Our Ref: WA/120/21/DOC

Town & Country Planning Act 1990 (as amended)
Town and Country Planning (Development Management Procedure) (England) Order 2015
Approval of details reserved by condition imposed under WA/55/21/L relating to conditions 3-sample panel of flint work & 4-details of landscape works.
Days Days Lane Aldingbourne BN18 0TA

Plans and elevations as proposed

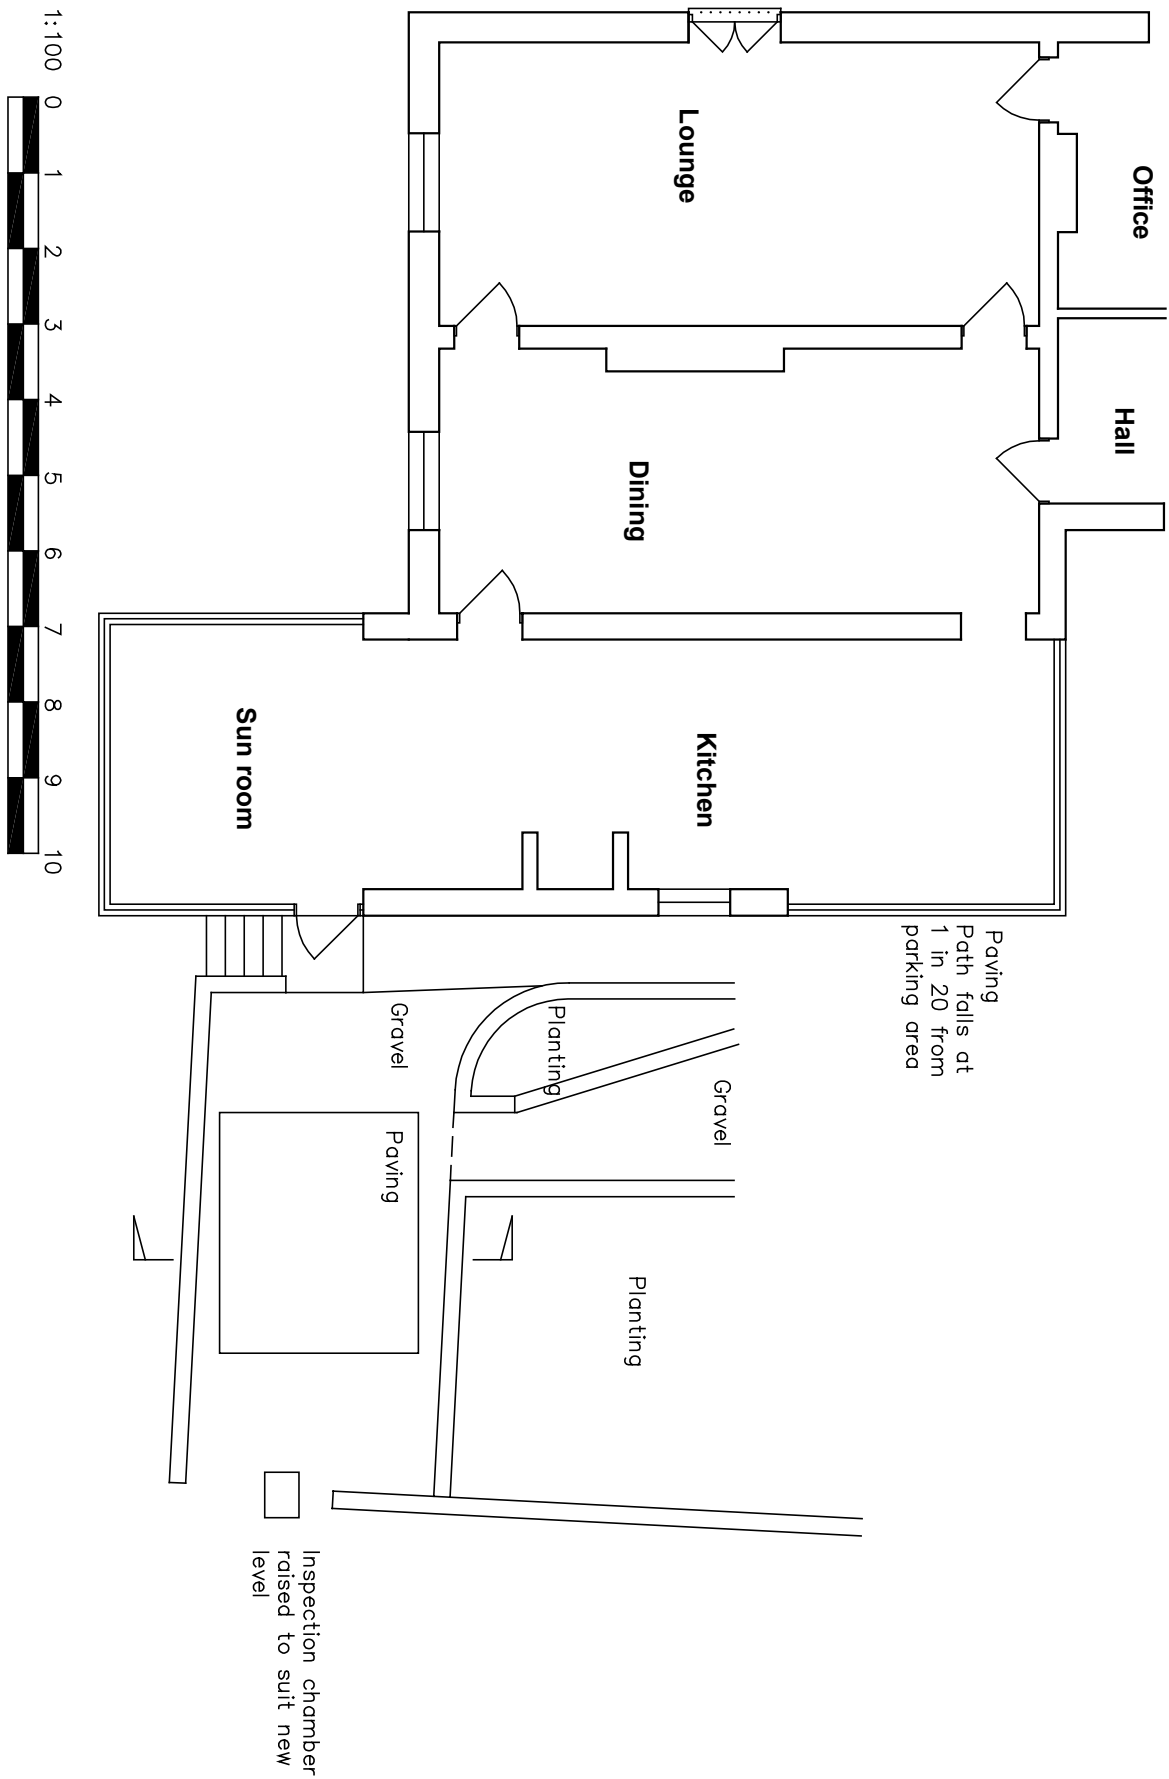
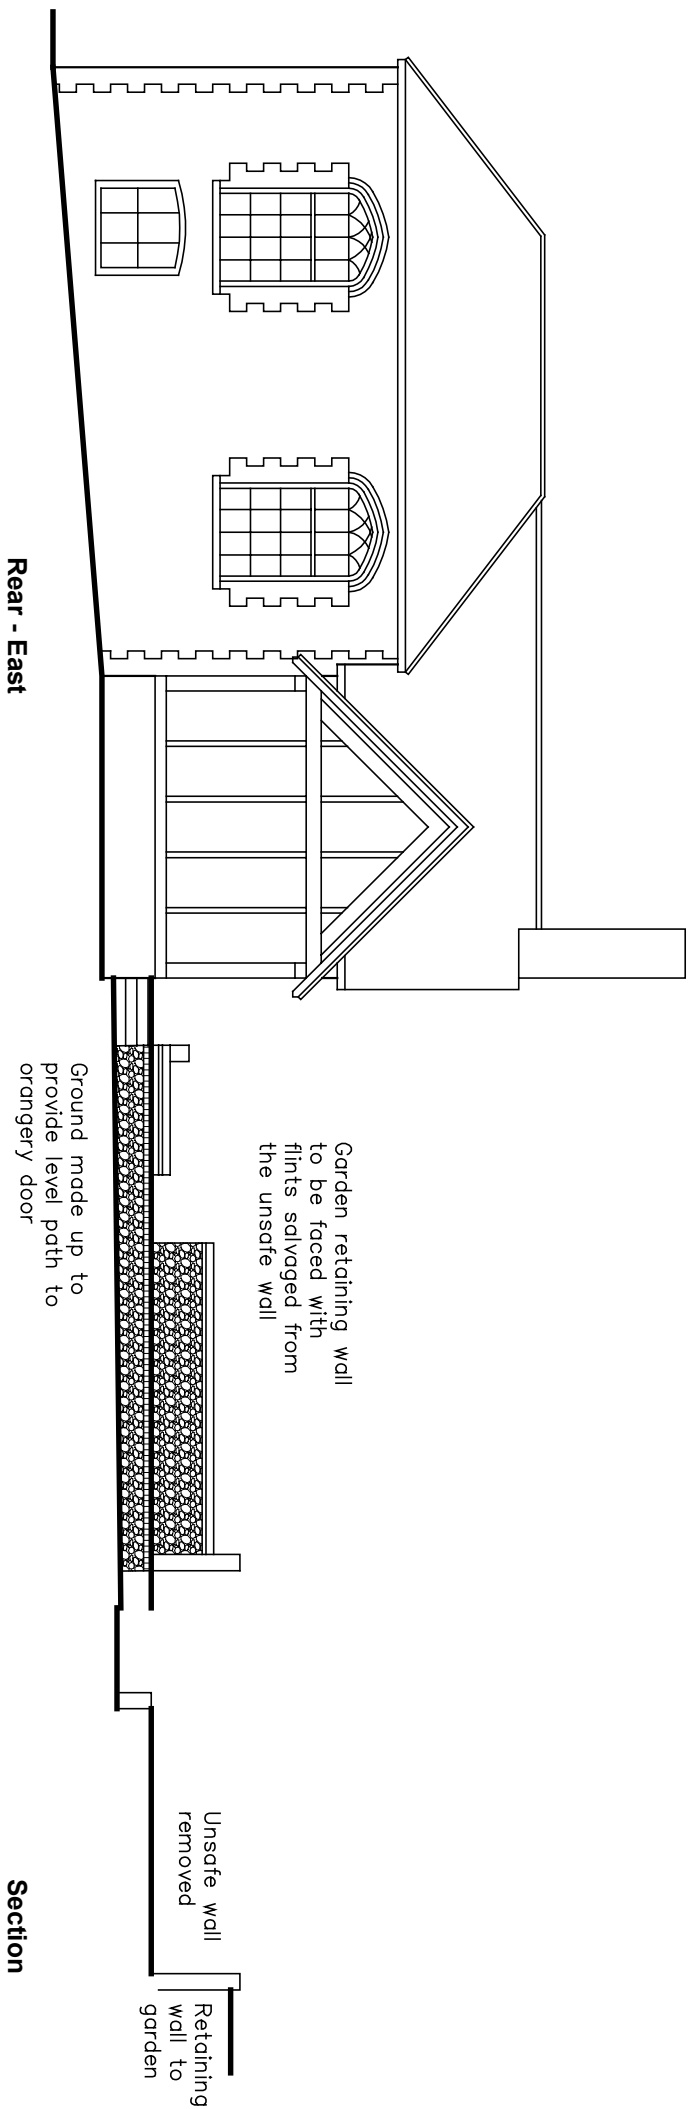
The submitted Dwg Nos 2805/01/03, Block Plan and 2805/01/02, Plans & Elevations as Proposed along with Photomontages have been appraised by ADC's Principal Conservation Officer who pointed out at some differences between the approved plans and those currently provided, however, as he concluded his comments, flint-work quality is acceptable and condition can be discharged.

The approval of this condition only approved the flint work and not any plans that differ from the original permission.

The condition is discharged on the understanding that the approved flint-work shall be constructed and the retained brick garden wall will be re-faced in these salvaged flints in accordance with the agreed details and retained in good condition thereafter.
